City of Portland, Maine – Building or Use Permit Application 389 Congress Street, 04101, Tel: (207) 874-8703, FAX: 874-8716

Re: Exterior Alterations; 103 Brackett Street. Window replacement, siding/trim restorations, fire escape/ deck structure, site improvements.

TO: Chair Wroth and Members of the Historic Preservation Committee
FROM: William B. Needelman, Planner
DATE: January 28, 1999
RE: February 3, 1999 - New Business

BUILDING PERMIT REPORT

PROPOSED Alterations to existing STAIRCASE, Apt # 4 from existing Living Room to upper Bedroom and Bath.

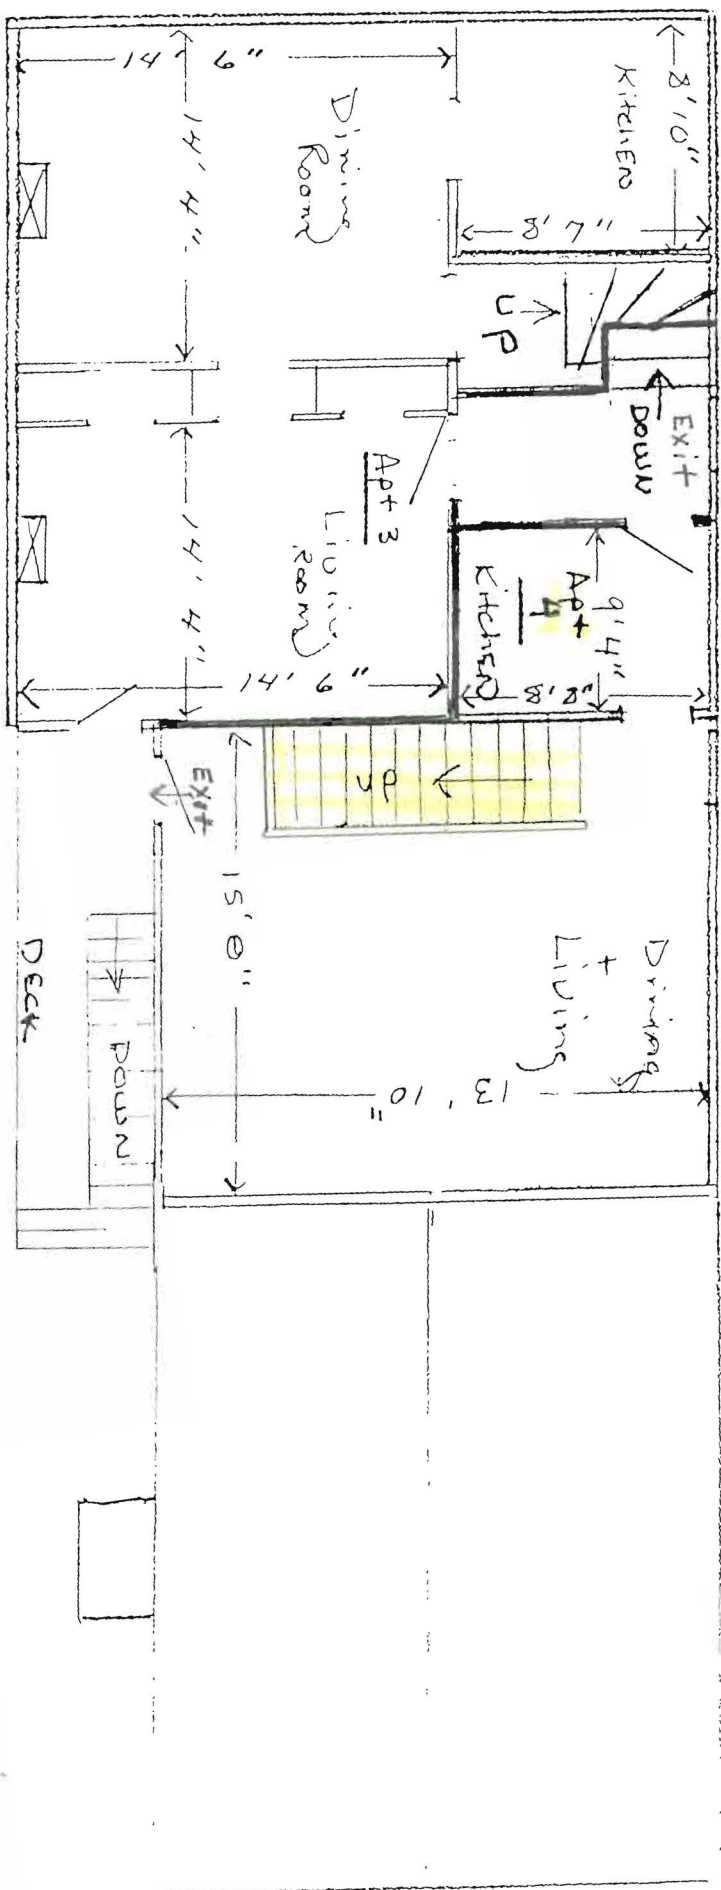
5-18-99 Lou Fourimer called for a R.I. on Plumbing had water test on OK on test, I talked to Mr. Crouther about the stairs on the 2nd to 3rd floor being 8 1/8 R. and 9" T. Told him to contact Sam about waver and to Recut carriage because of over cut at the throat of several stair points. (TR)
200 High St office
